Our Ref: PEF/SD/28854
Your Ref: Y/21/18/DOC

Drainage Land at Kings Close, Yapton

Further to receipt of your e-mail dated 3 May 2018, please find herewith the following calculations and drawings:-

PROJECT
 Standard Detail
 High Storage Soakaway

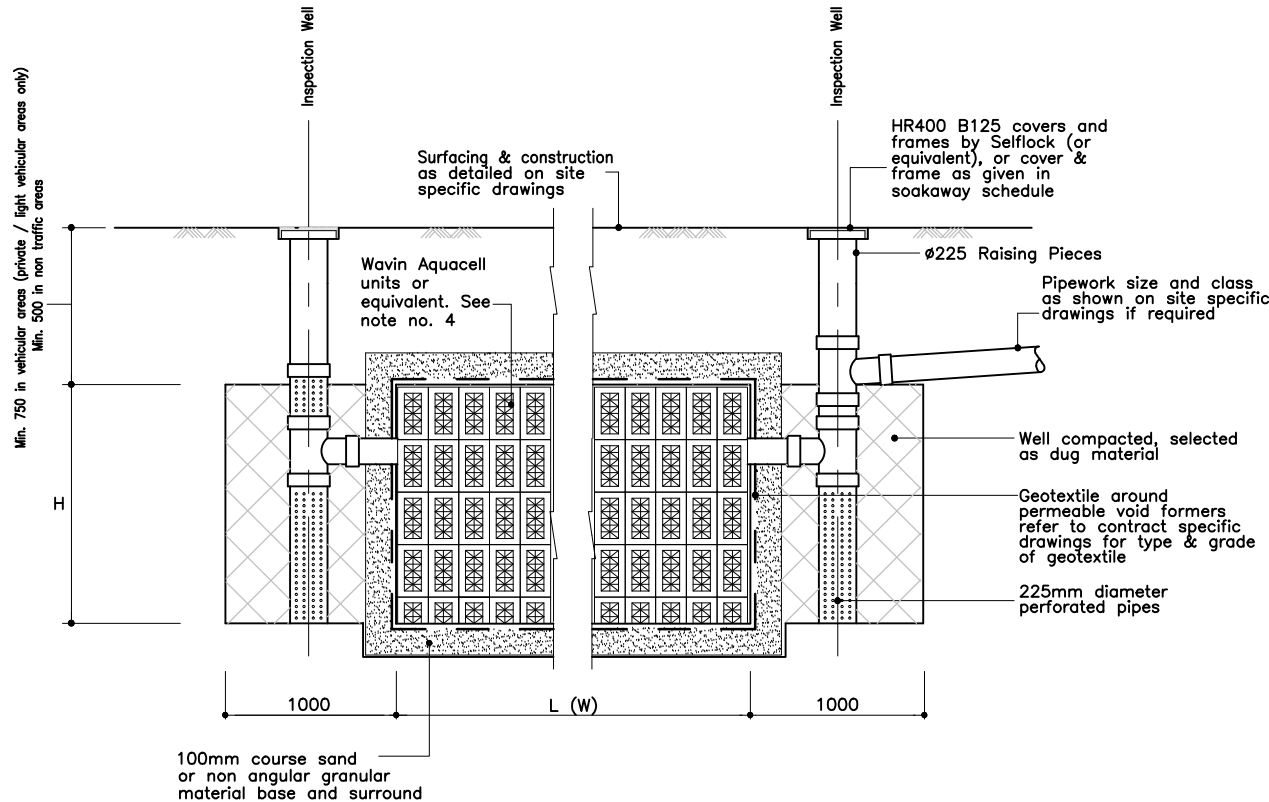
- 1) The high storage soakaways have been redesigned such that the half drain time does not exceed 24 hours. See Micro-Drainage calculations.
- 2) In order to control exceedance flow in the vicinity of Kingshaven, I have introduced a raised speed table and permeable paving. See drawings 28854-101.P5 and 102.P3.
- 3) Free draining Class 6N backfill is being provided behind the new retaining walls. See drawing 107.P2. I have also introduced a hydraulic break at the edge of the permeable pavement on the west boundary of the site. The hydraulic break will help retain storm water within the base of the permeable pavement and restrict flow towards and through the new King post retaining wall.
